WEST SUSSEX COUNTY COUNCIL CONSULTATION

TO:	Arun District Council FAO: James Cross
FROM:	Stephen Gee WSCC - Highways Authority
DATE:	24 May 2021
LOCATION:	Warwick Nursery Barnham Road Eastergate Barnham PO20 3RT
SUBJECT:	BN/153/20/PL 44 No. dwellings & associated infrastructure. This site falls within the BEW Strategic Site, CIL Zone 1 (Zero Rated).
DATE OF SITE VISIT:	n/a
RECOMMENDATION:	Advice / No Objection
S106 CONTRIBUTION TOTAL:	TBC

Drawing Title
Proposed Site Layout

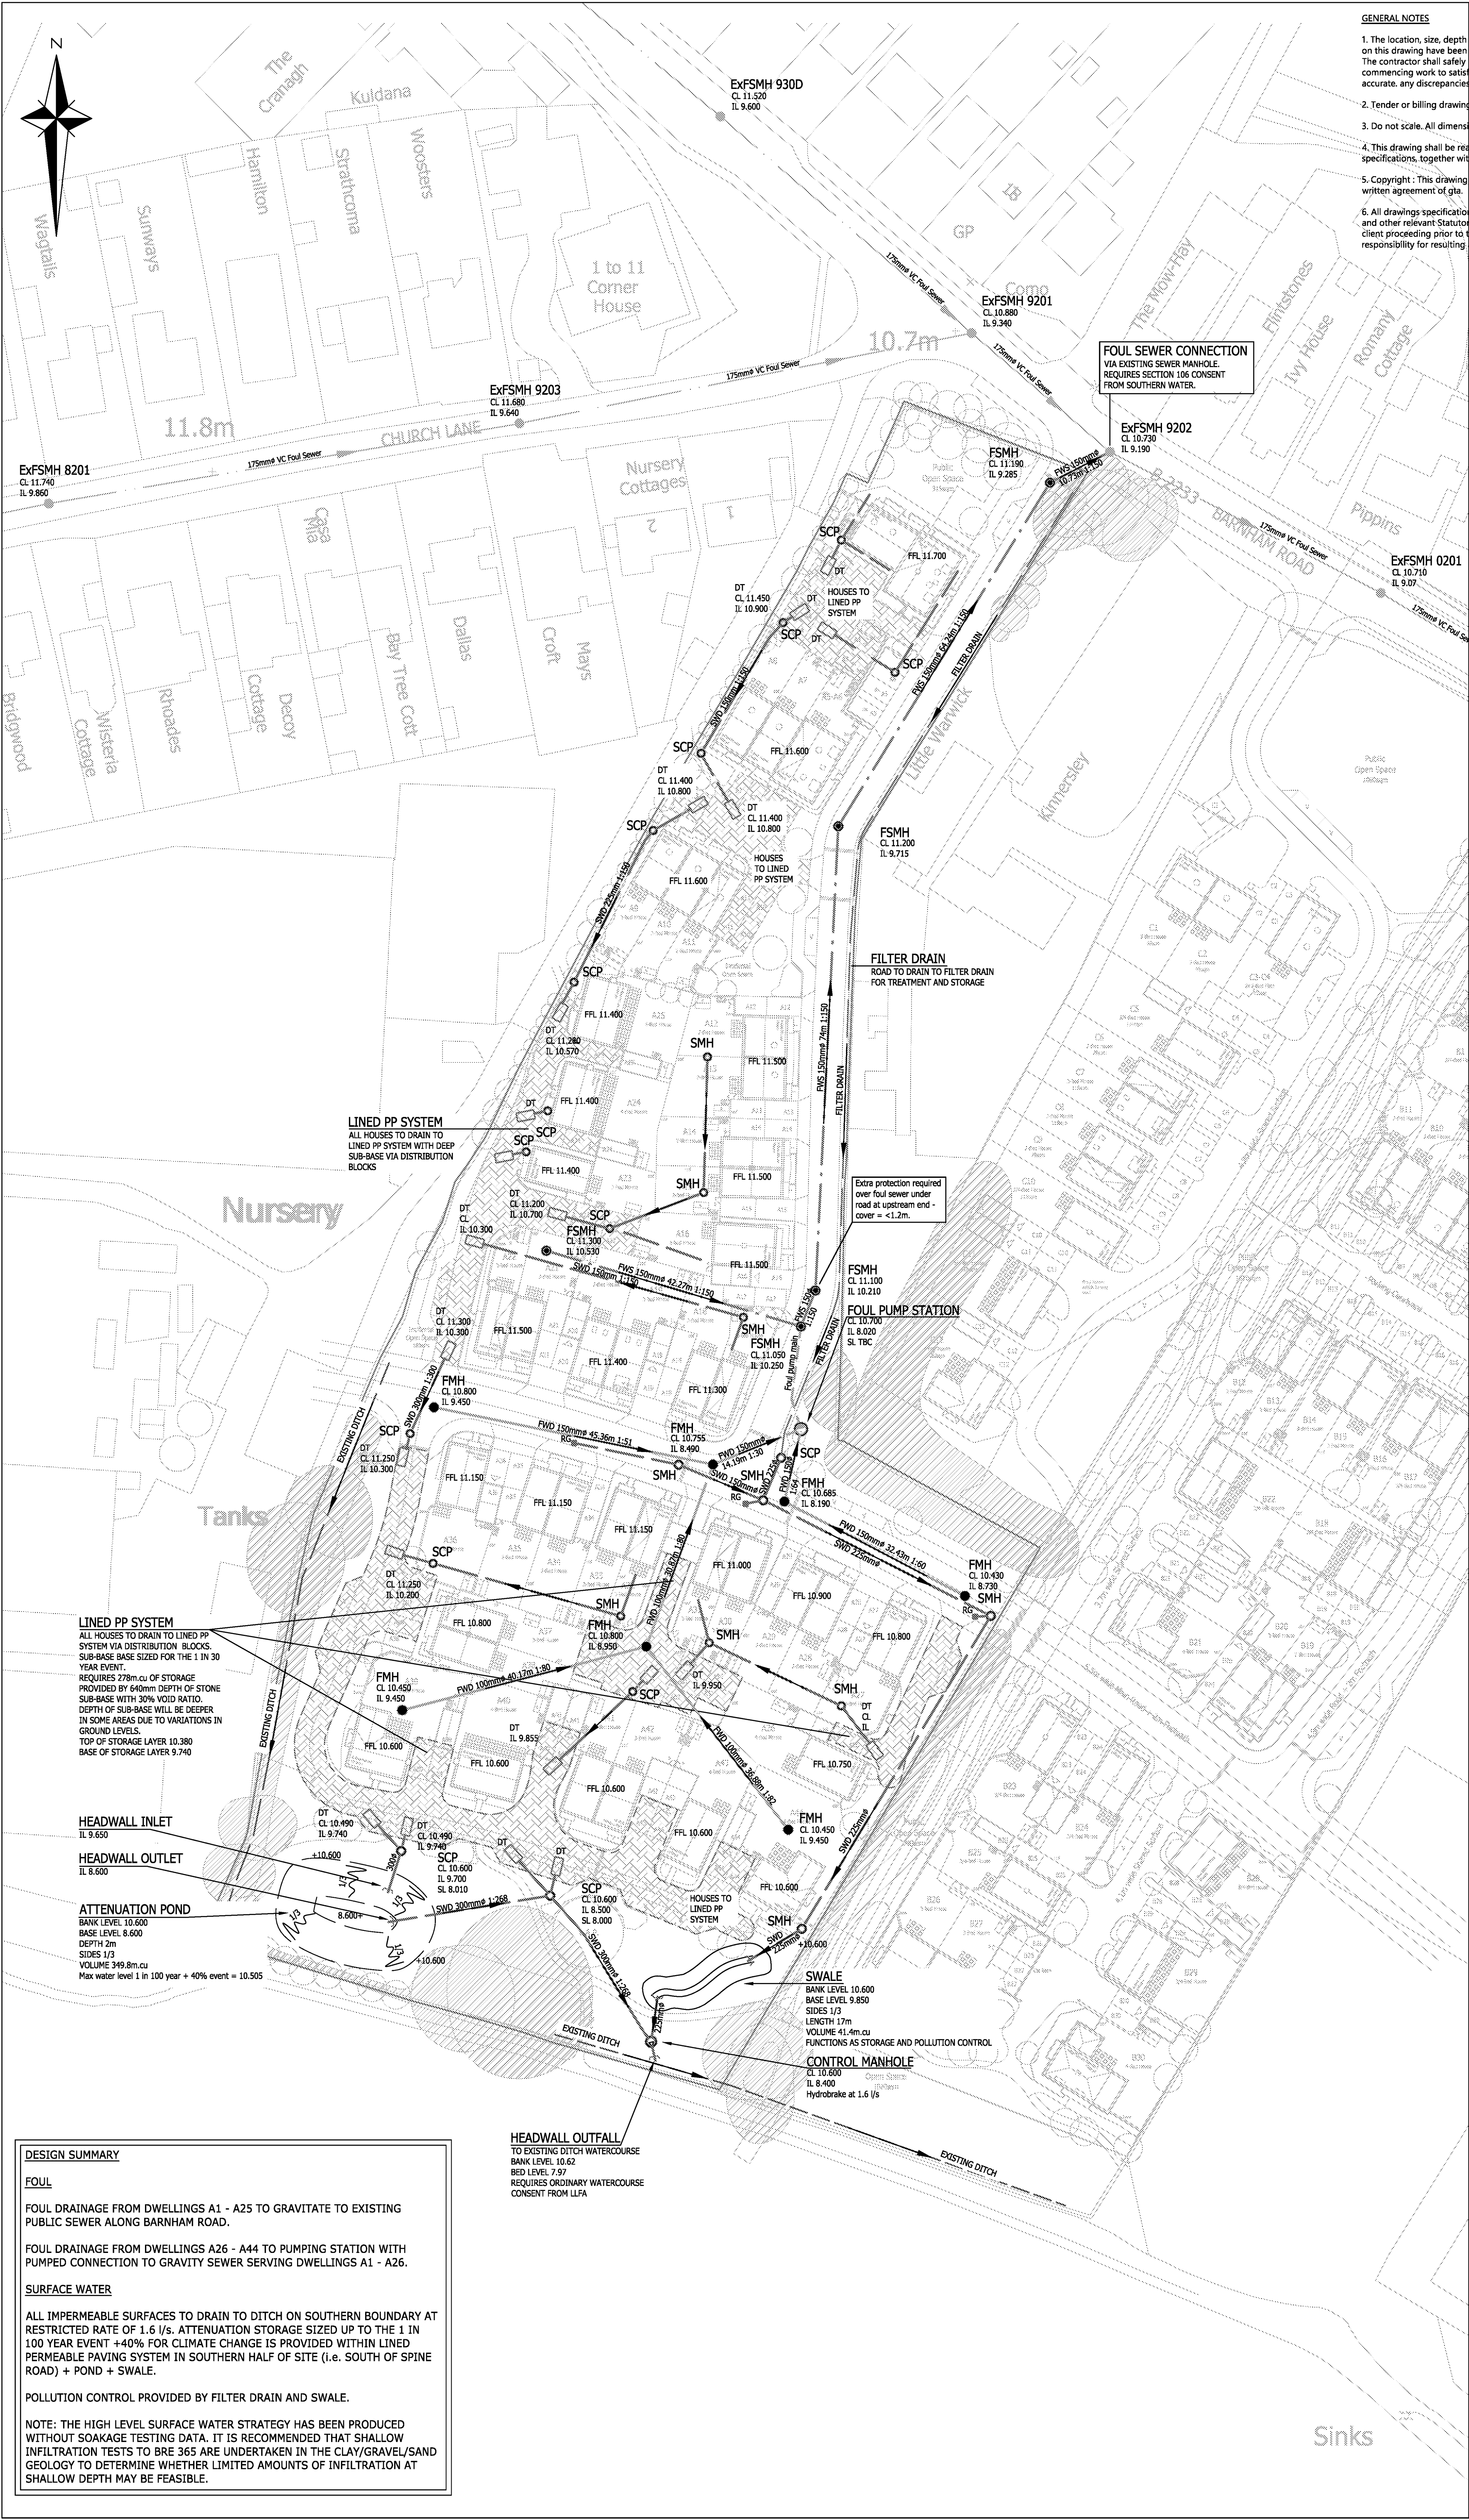
A temporary turning head is provided to the south east of the development and would allow refuse vehicles to serve the site in advance of adjoining developments coming forward.

The provision of visitor parking across the development remains very imbalanced, however an extra space has been provided to serve the northern element of the development. This raises the total to 15 across the site, again a reprovision across the site would be preferable but would not result in a reason for refusal.
